Church Farm Accommodation
Church Lane
Bickenhill
Solihull
B92 0DN

The Inspector
M42 Junction 6 DCO Hearing
The Planning Inspectorate
Temple Quay House
2 The Square
Bristol
BS1 6PN

**Re. Representation of David and Camilla Burton of Church Farm Accommodation,
Church Lane, Bickenhill B92 0DN**

Deadline 8 Submission

**OPTION 1: INDICATIVE ALT. ARRANGEMENT TO REDUCE IMPACT ON CHURCH FARM LAND**

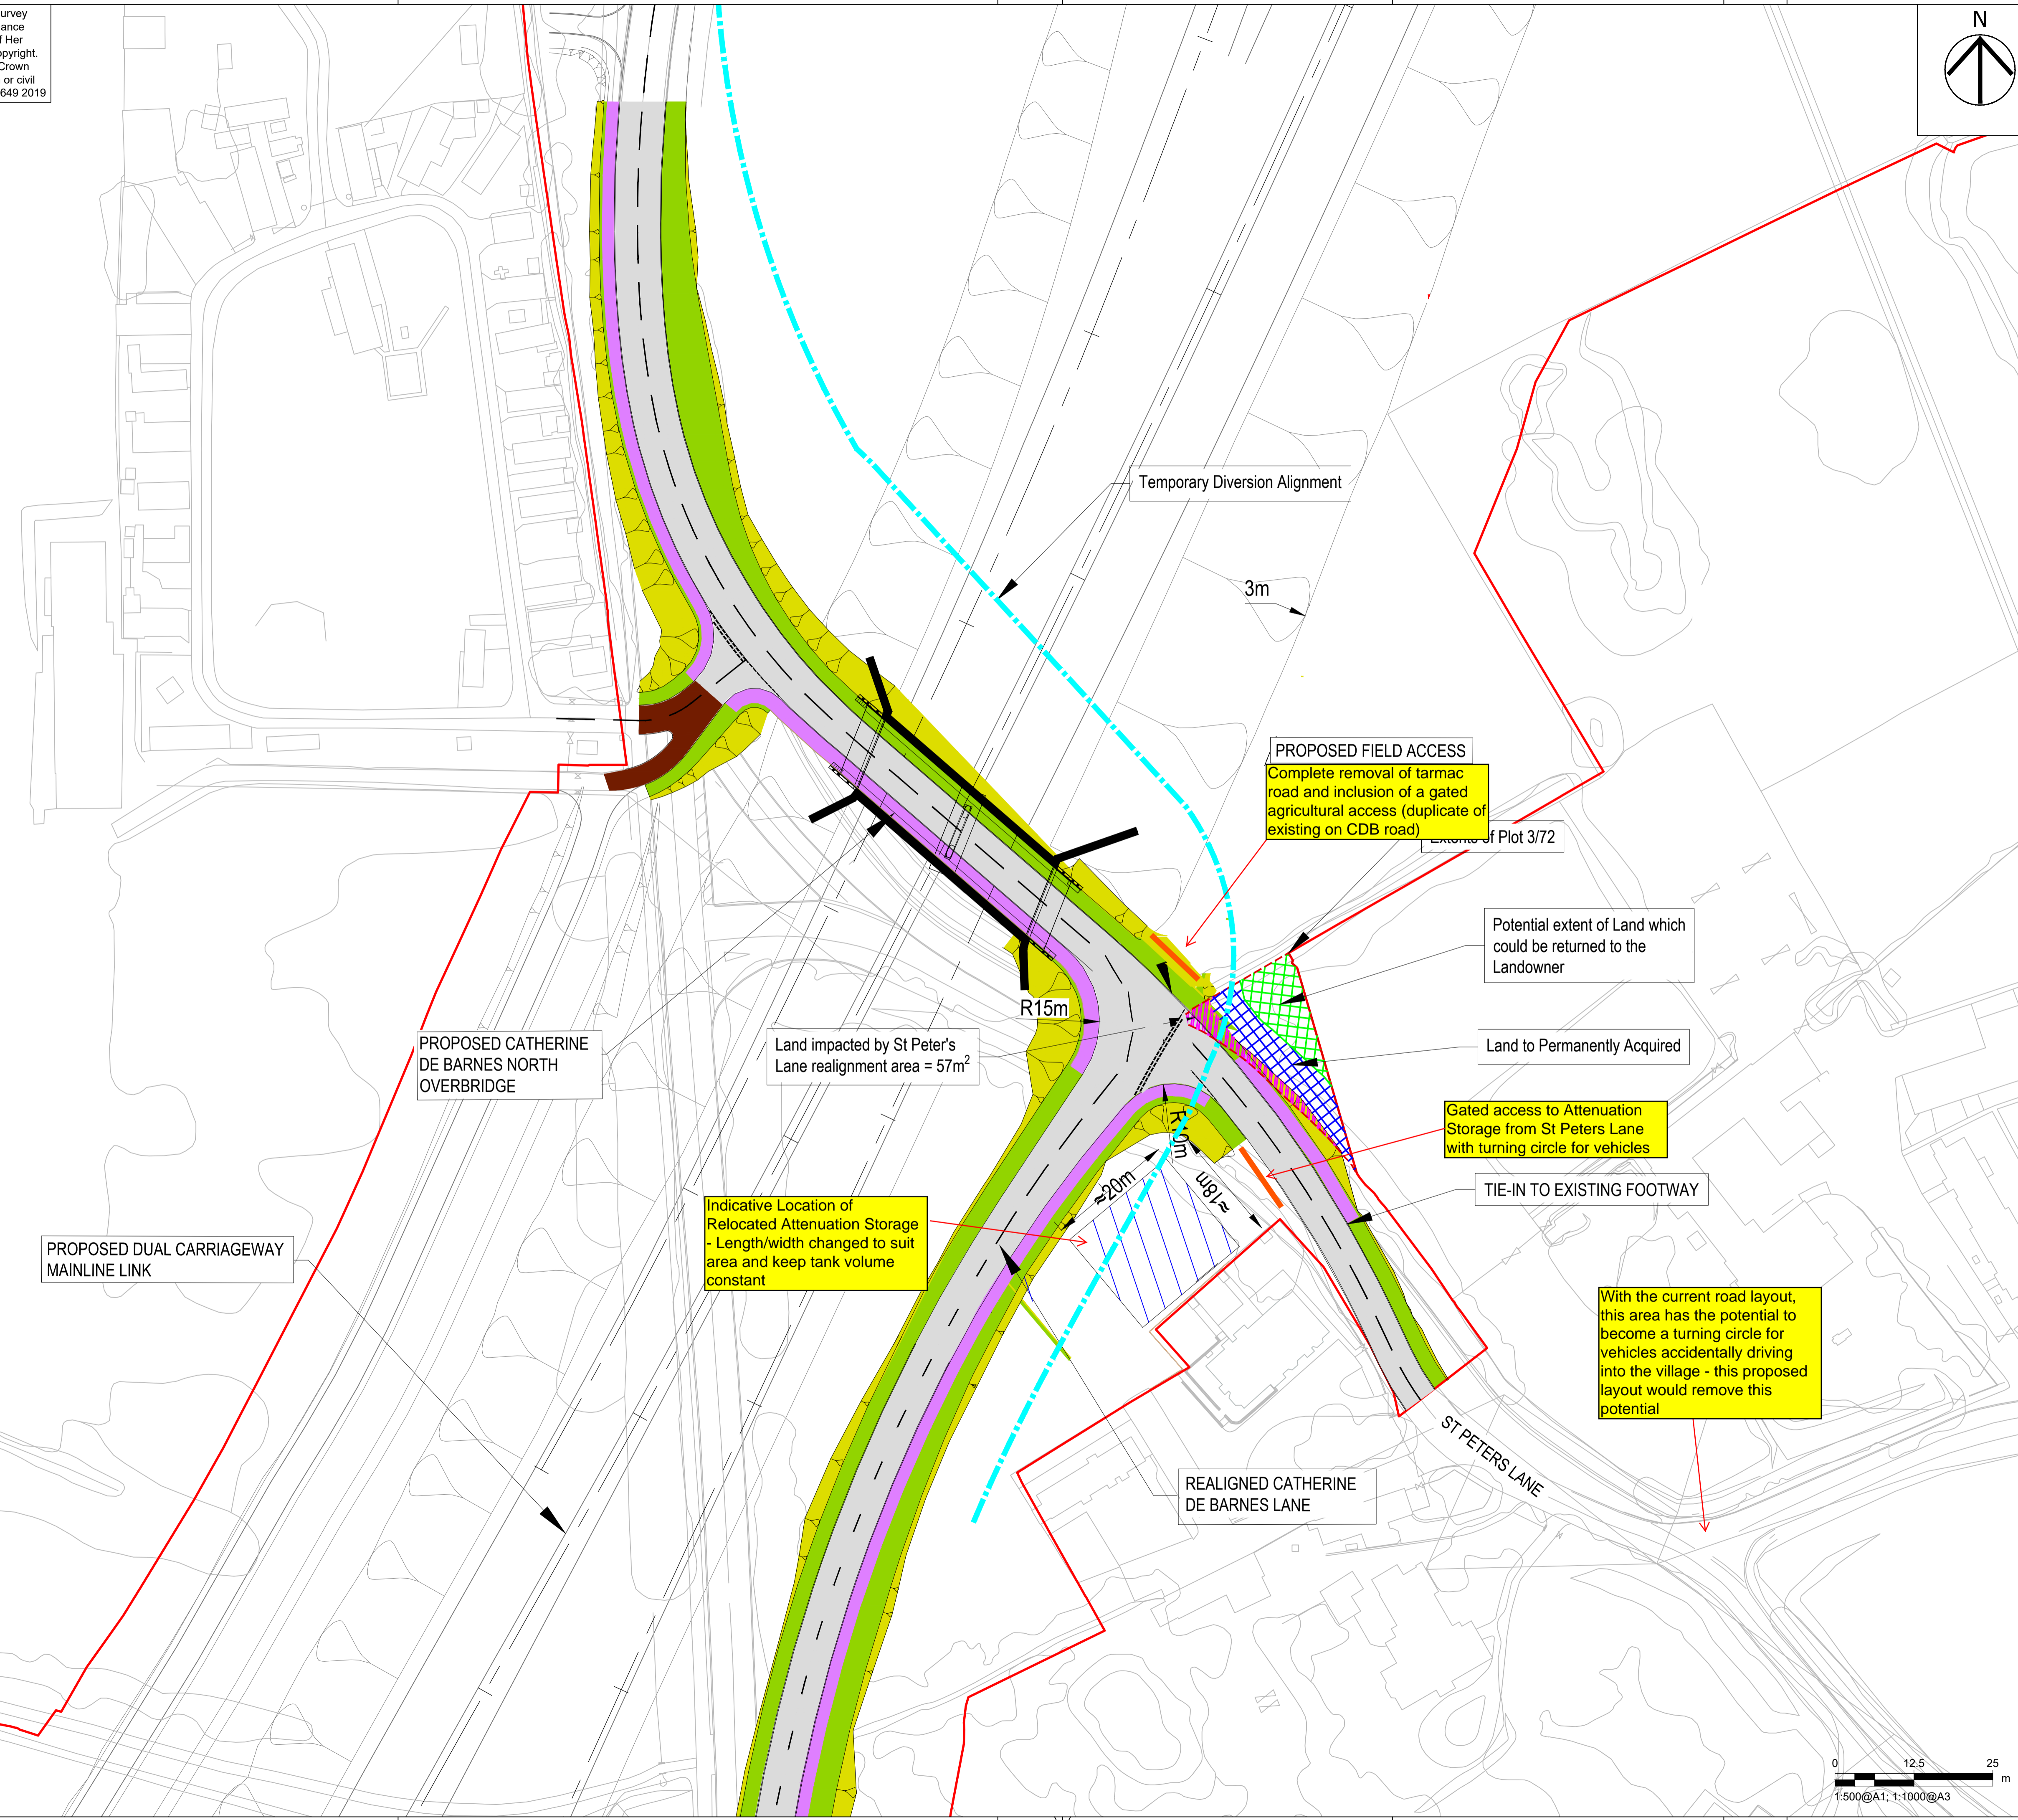
Attenuation tank siting

From their replies, we **do not** believe that HE have reviewed our proposal in sufficient detail, and therefore our strong objection to their proposal to site the attenuation tank to the north of St Peters Lane remains.

Firstly, HE State that that visibility when exiting the site of the proposed relocated attenuation tank would be impaired as the access would be on a tight bend in the road. Currently this is correct but, as can be seen on plan HGN-SK-CH-0151, submitted by HE in document 8.86 (pg. 25), the restructuring of the junction removes the tight bend referred to as a reason for discounting this. The restructuring of the road would also remove some or all of the tree obstructions referred to as another reason for discounting this proposal. The traffic coming out of the village will also be minimal and there are many other properties along St Peters Lane that have a similar access/egress to that proposed which are used on a daily basis, not a twice per year basis (as advised during the ISH on the dDCO meeting of the 23rd October 2019). This therefore becomes an invalid argument for not relocating the attenuation tank.

Secondly, the access considered in Volume 8.73 [REP6-015/Volume 8.73] was an access directly off the realigned Catherine-de-Barnes road – our submission suggests an access off the quieter, local road of St Peters Lane. As the attenuation tank will only be accessed on a bi-annual basis, this will result in a vehicle accessing the same area proposed if the attenuation tank is located on the north side every 6 months.

In addition, as the restructuring of St Peter Lane causes this to now be a virtually straight road, access to the current position to the north, and access to the proposed position to the south will be virtually identical – we would even suggest that the access turn left through a gate on the north side of St Peters Lane would propose an even greater risk as stationary traffic is likely to be positioned on the junction between the realigned Catherine-De-Barnes road and St Peters Lane. Our suggestion takes this traffic off the main road and onto the very start of the local road, reducing this danger.

In relation to the land take mentioned – the land is already being utilised for the temporary realigned Catherine-De-Barnes road while the bridge is being constructed, has already been marked for environmental mitigation and is already included within the scope of the dDCO. The land will already be impacted and therefore will not be further affected.

The argument regarding the constraints for the tank is a little insulting – surely if HE are capable of designing a full road infrastructure, they would be able to design a tank to fit within the pocket of land to the south of St Peters Lane, removing the need for the tarmac access road behind our property? It may not be as simple as the north site but a small amount of work on the part of HE has the potential to make a large difference to our business/home, without impacting to any greater degree on others.

Due to the points above, we suggest that there is **no valid argument against relocating the attenuation tank to the south of St Peters Lane** and we are also dismayed at the obvious lack of assessment of our proposal by HE given the responses submitted, in particular to the access/egress from the site suggested - it appears that HE are trying to rely on old responses given in previous submissions for a revised and very genuine proposal to try to overcome some of the major difficulties which we have identified at present.
